**WEST SUSSEX COUNTY COUNCIL
PLANNING SERVICES CONSULTATION**

SUBJECT: R/88/17/OUT

Outline application with all matters reserved for 1 No. dwelling & detached garage.

40, Bushby Avenue, Rustington, BN16 2BX

General Arrangement Plan ~ As Proposed

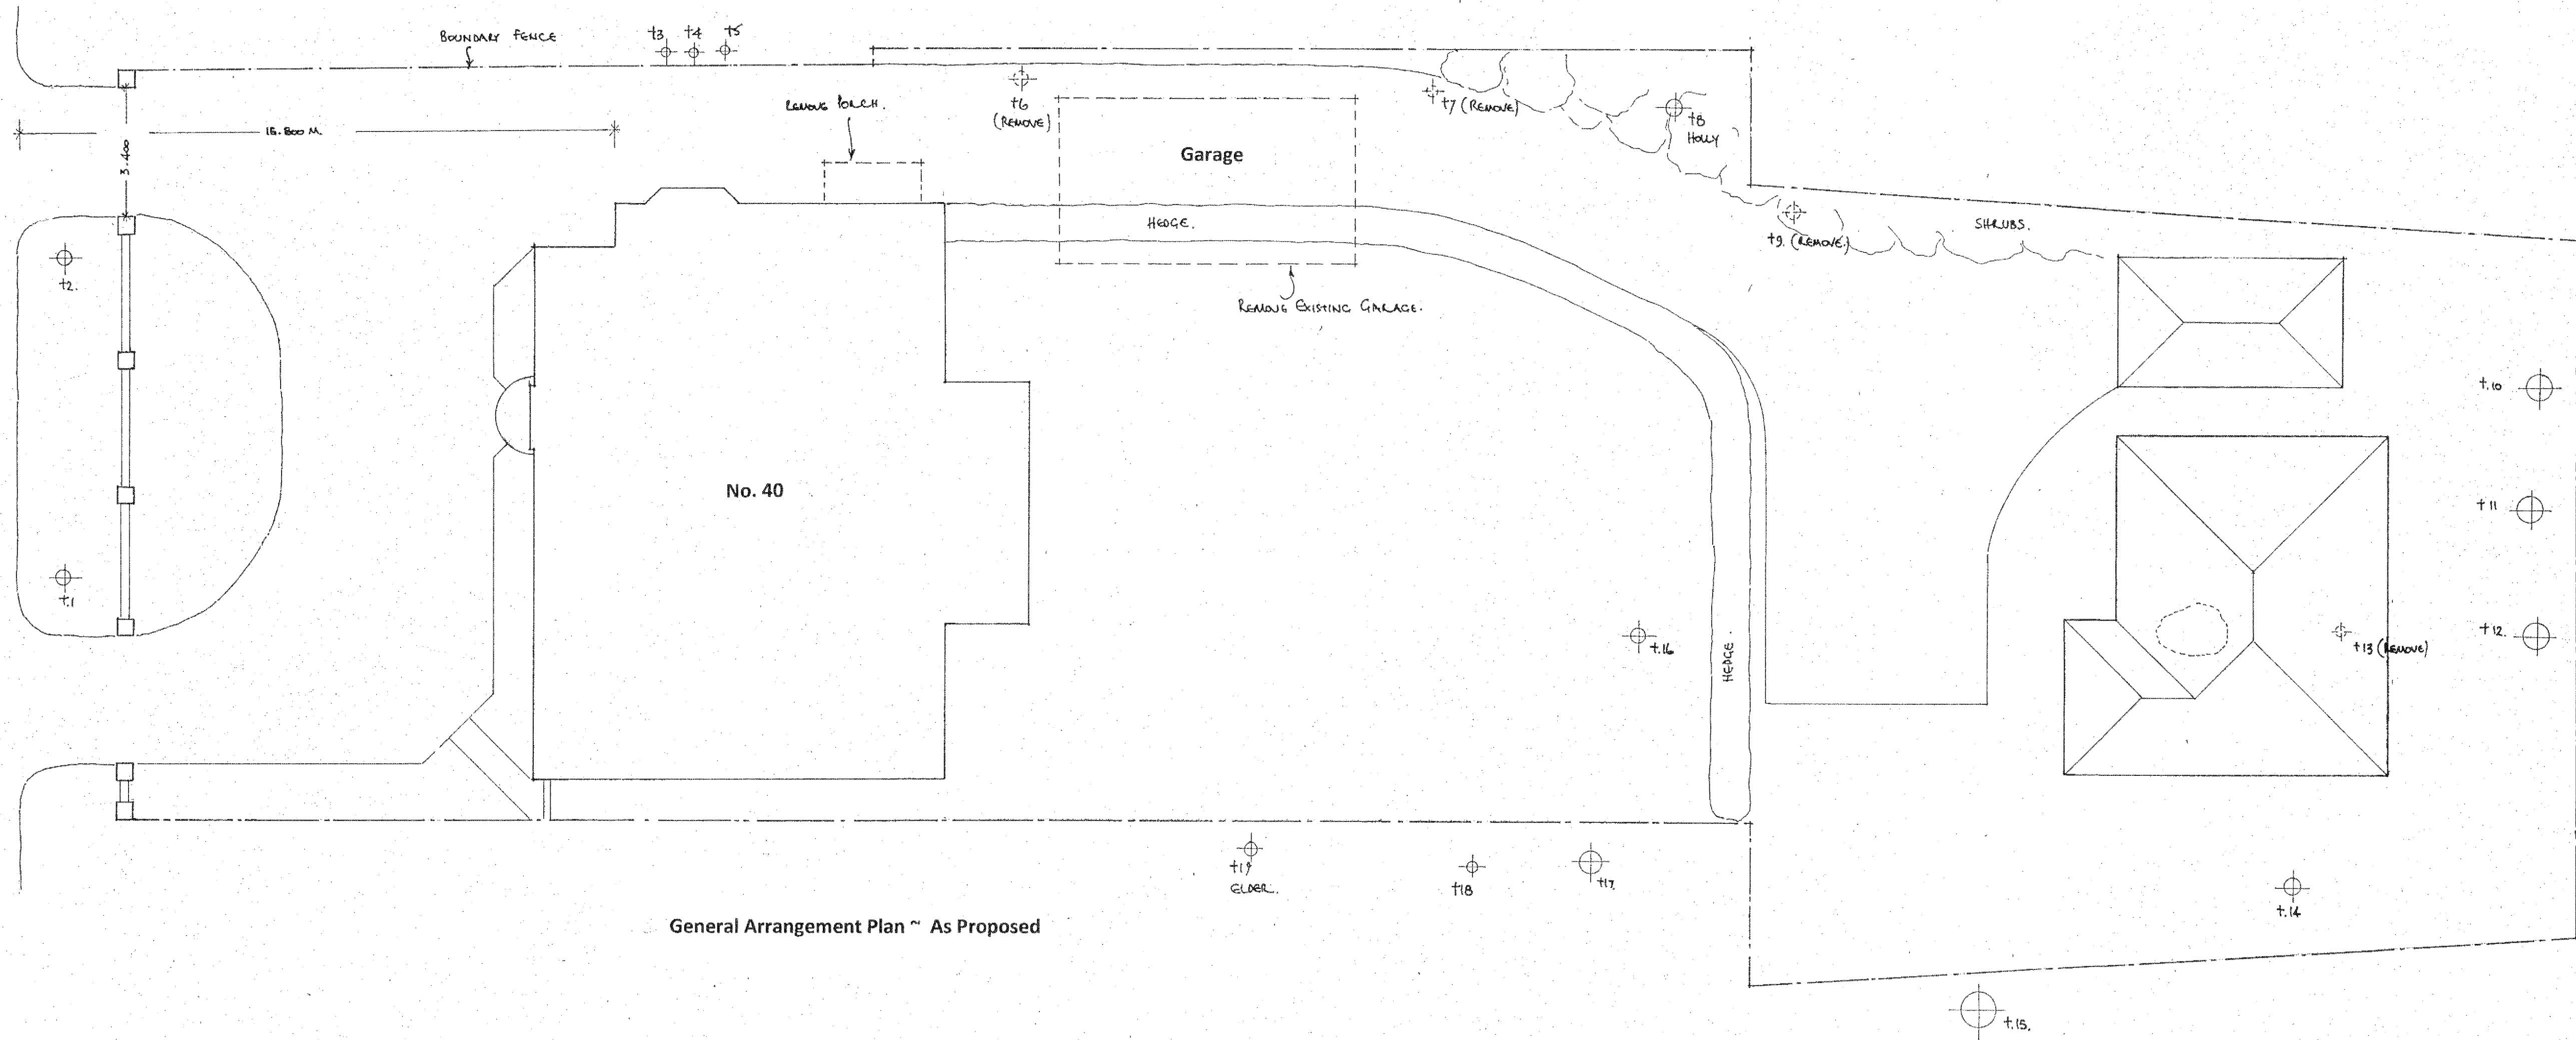
Access is to be obtained via the existing arrangement onto Bushby Avenue, and turning is to be provided within the confine of the site to enable a vehicle to enter and leave in forward gear. An operating width in excess of 3.7m is provided for in front of the dwelling to enable a fire appliance to operate at the site in the event of an emergency, with an access drive width in excess of 2.7m allowing the appliance to access the site.

No objection is raised.
